In addition to our previously submitted comments on the scheme Phil Freer, [REDACTED] of Bridge House Farm / Bridge House Boarding Kennels NG24 2AA would like to include for consideration the following:

**Figure 2.1: Noise measurement locations**

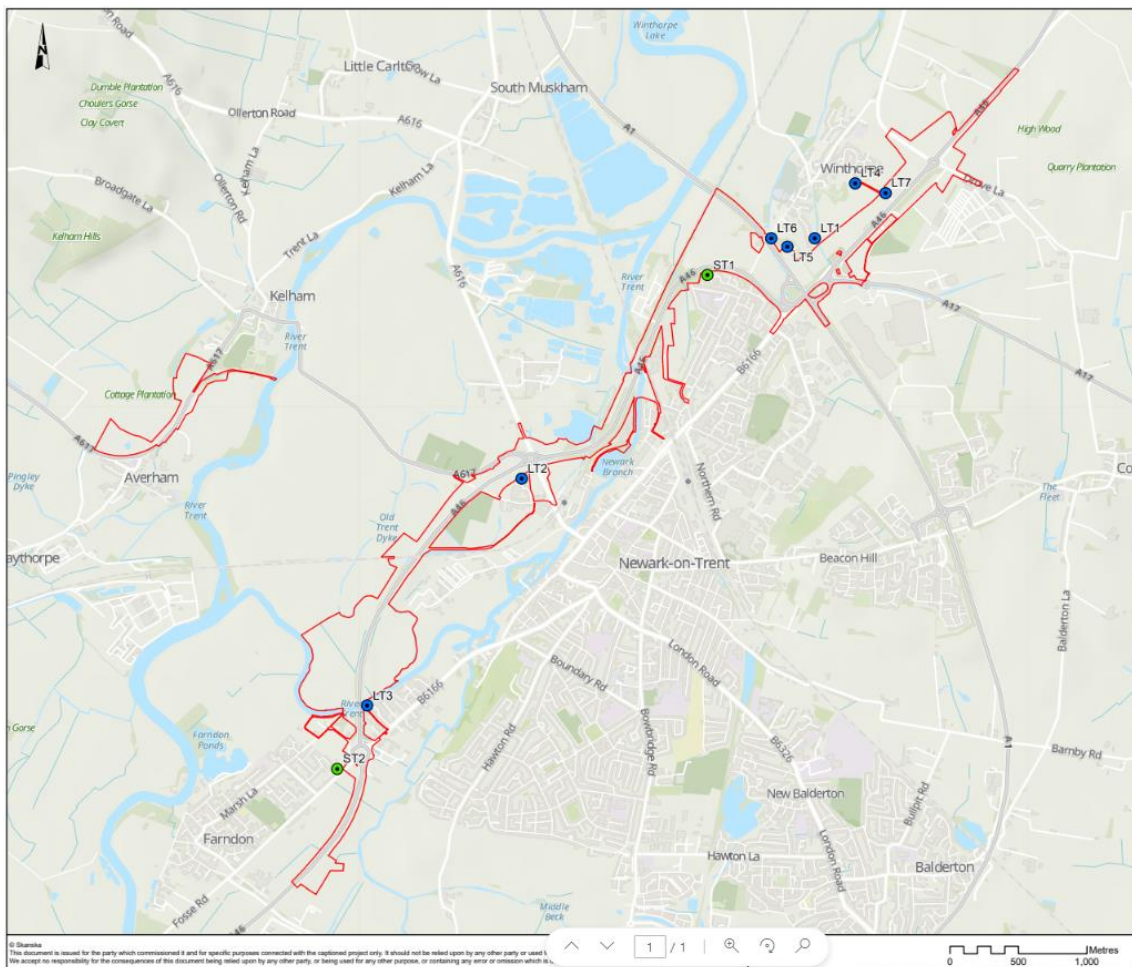
- There has not been an acoustic receptor placed or used to record current noise levels at Bridge House Farm where there is to be the development of the Brownhills junction to include a roundabout, slip road and 4 lanes of 10m high A46 new road. The nearest receptor was placed on the opposite side of the A1 to where these new constructions are being built. We would request an acoustic receptor at our location to monitor current noise levels before the development and that the results are made known to us.
